Exhibition of State Significant Development (SSD 9153) 4 Darling Street, Marsden Park, Part Lots 303 & 304 and Lot 305 in DP 1213756 Notice of Exhibition.

The proposed State Significant Development (SSD 9153) 4 Darling Street, Marsden Park, has been assessed by TransGrid's Transmission Line and Cable Engineers, in accordance with TransGrid's Easement Guidelines and requires the following conditions to be met and included in any revised plans for the site.

Drawing		SITE PLAN	
Drawing Number		118101_A100	
Issue		N

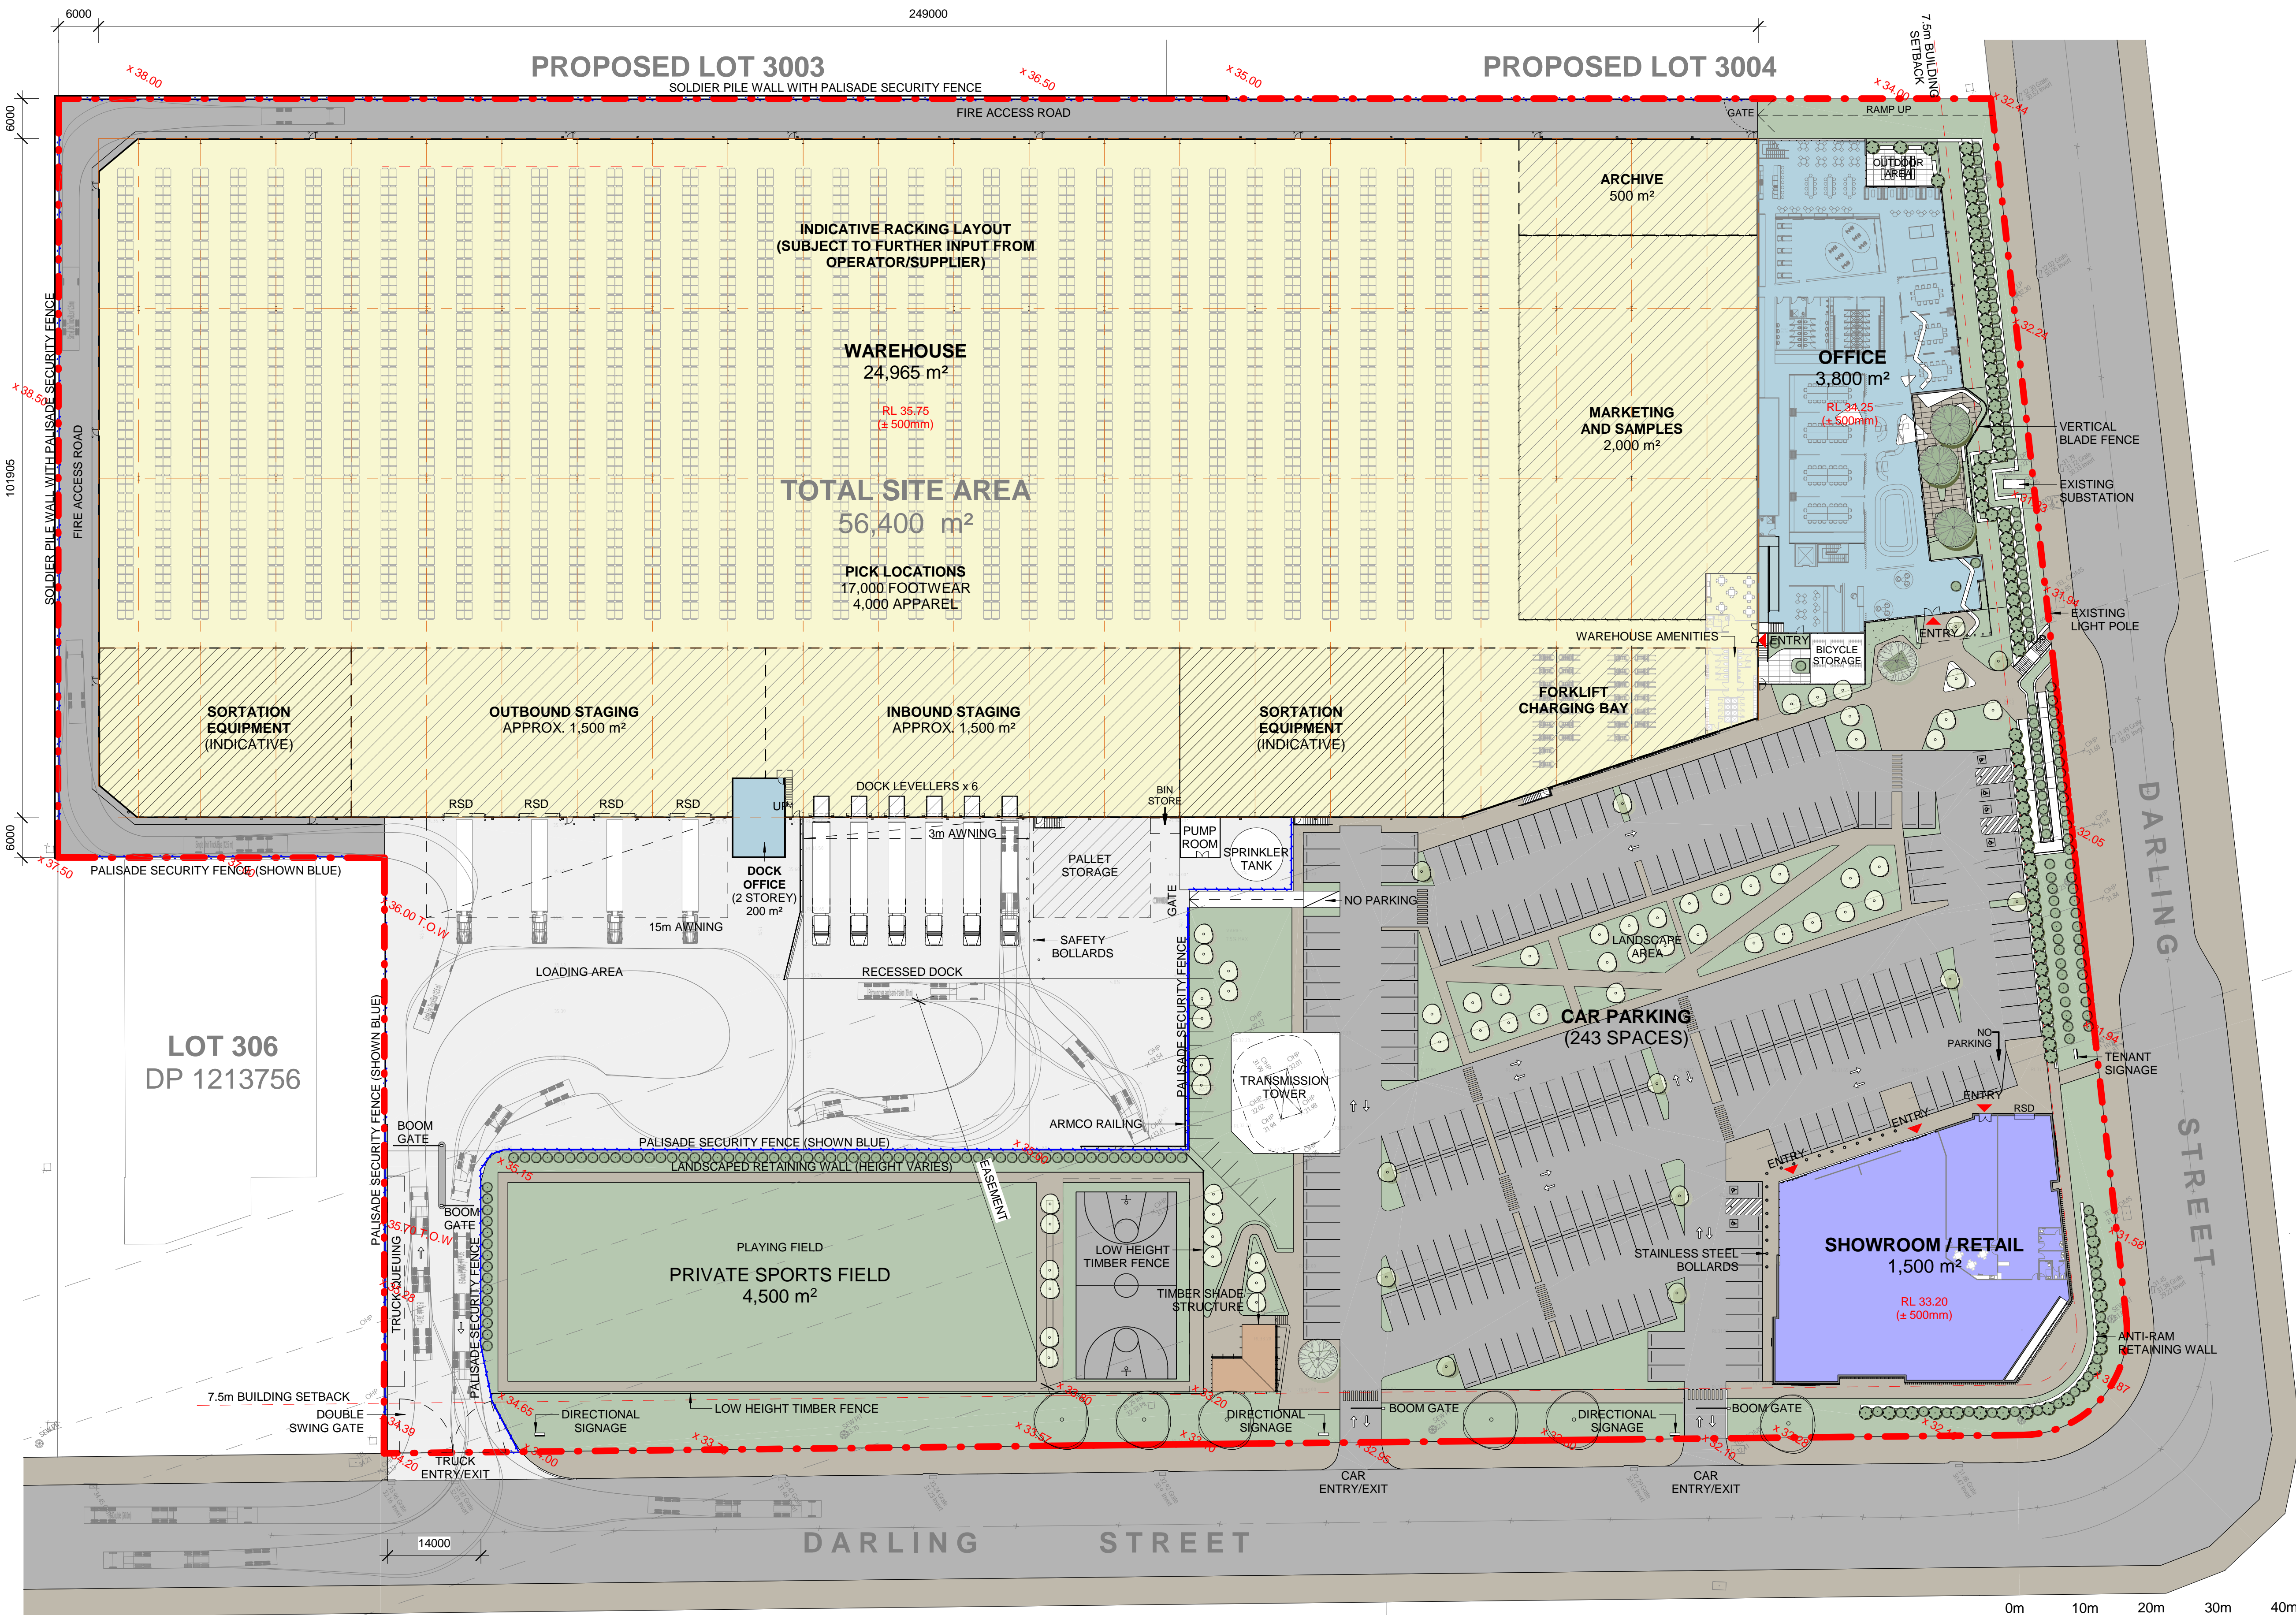
1. There can be no car parking spaces **within 17m** of the transmission line centreline or **20m** of the transmission line structure in accordance with the TransGrid Easement Guidelines

2. The thoroughfare areas of the carpark closest to the structure should be relocated to be as far from the structure as possible once the parking space locations have been modified. If the paved area remains within 20m of the structure the proponent may be liable for costs incurred to relocate the buried structure earthing. It is preferred to have the vehicle thoroughfares greater than 20m from the structure

- No perimeter fencing and gates are proposed around the development site and access is to be available at all times
 - It appears that carpark spaces have mostly been removed from the 20m exclusion zone (as discussed in meeting)

3. Please note that part of the proposed Palisade Security fencing and Armco Railing within the site are shown to be within the 20m exclusion zone. Any fencing proposed within the easement is to be installed in accordance with TransGrid's Fencing Guidelines (attached).

DETAIL LANDSCAPE PLAN (PRIVATE OPEN SPACE)
SCALE - 1:200

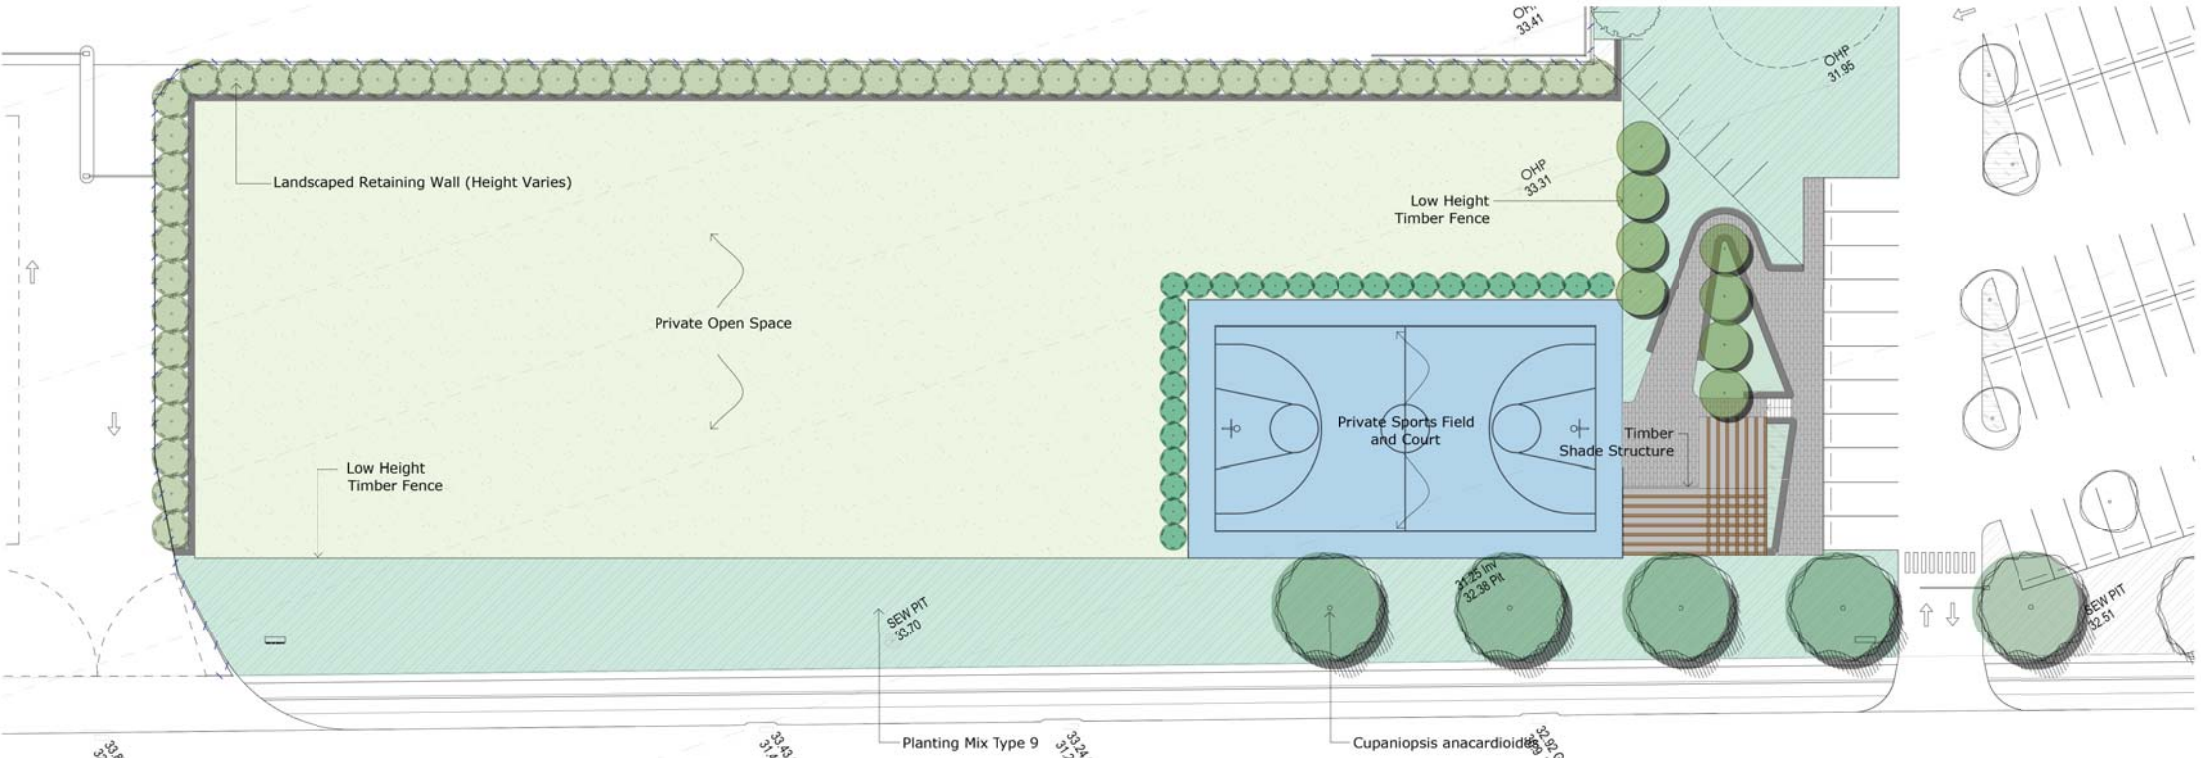
3. The proposed sports field and basketball/tennis court are not in accordance with TransGrid's Easement Guidelines (attached). Such facilities, whether public or private, should be at least **17m** from the transmission line centreline
